DRB Project Case #: 1006813

Subdivision Name: BELMONT PLACE BLOCK 2 LOTS 22A & 24A

RE: Lot 22-24, Block 2, Belmont Place/p&f

RE: Lot 22, 23 & 24, Block 2, Belmont Place Addition/sketch

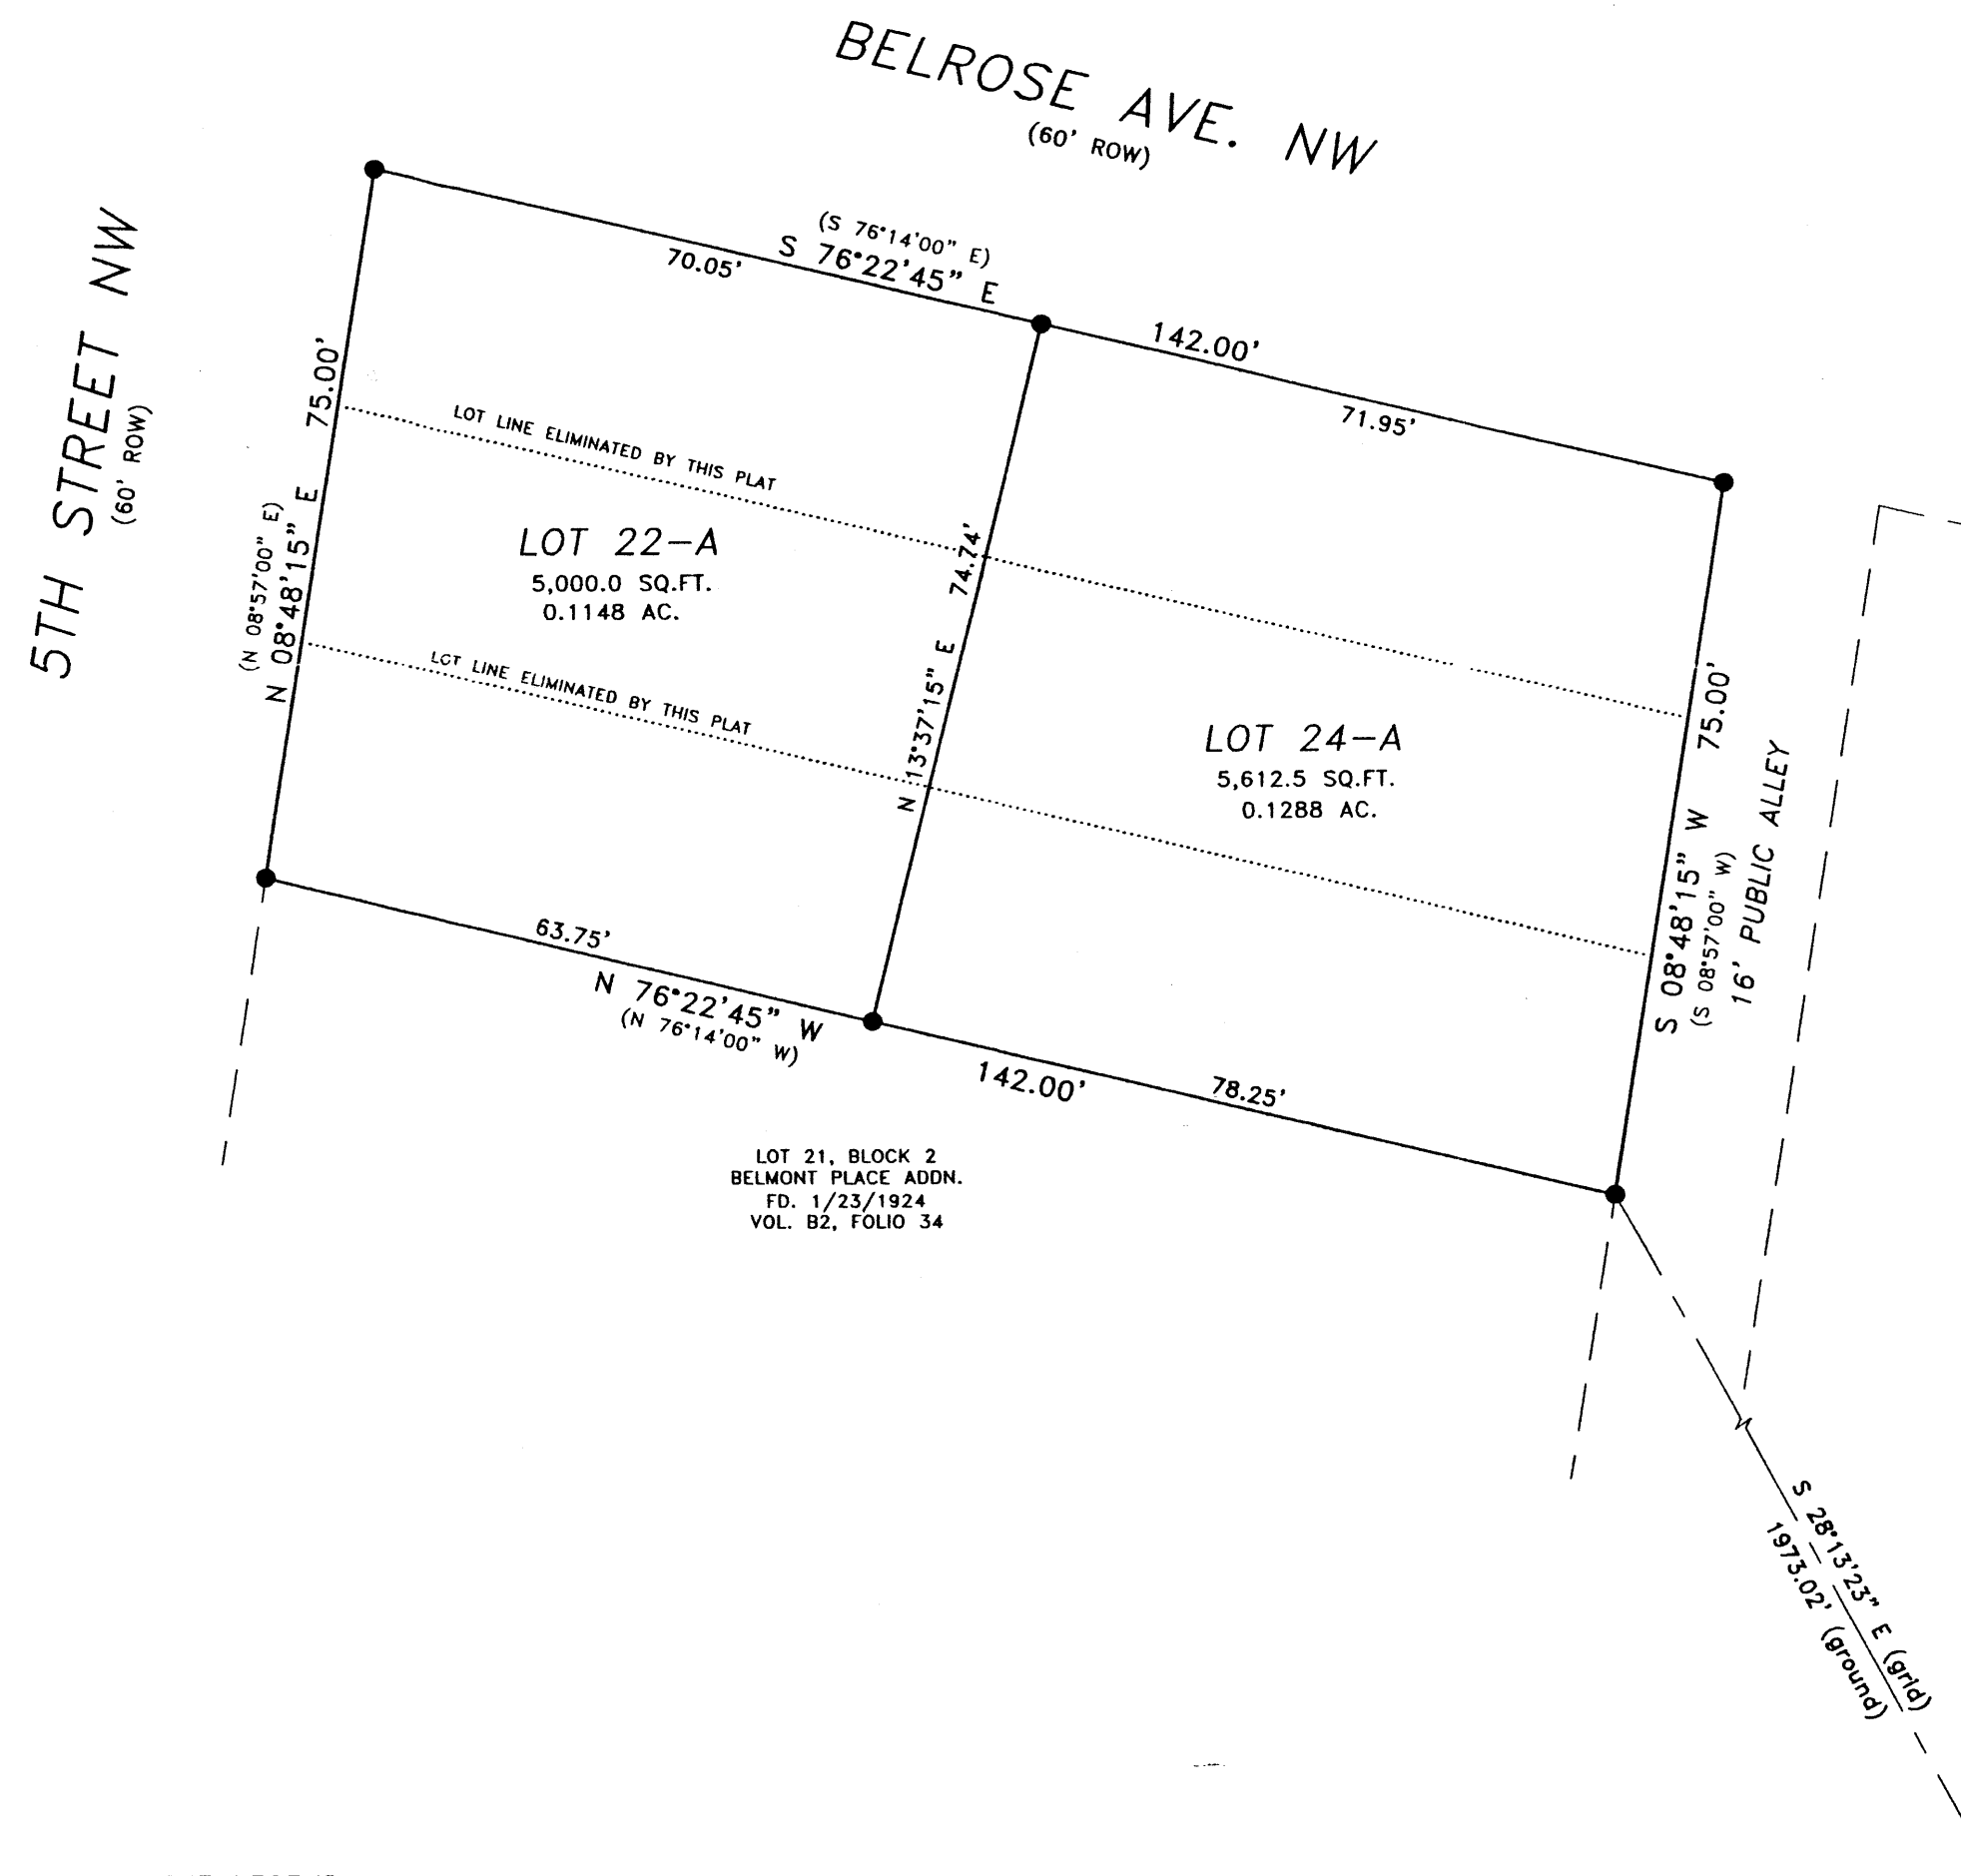
The proposed lot B has an accessory building on it. The R-1 zone in The City of Albuquerque Comprehensive City Zoning Code does not allow an accessory building on a legal lot without a primary residence on it.

Will access be taken off of the alley? (If access is being taken off of the alley, the alley must be 24 feet in width and paved) - *No access off alley*
Dedicate an additional 2 feet of right of way to the alley width. - *take delegation*
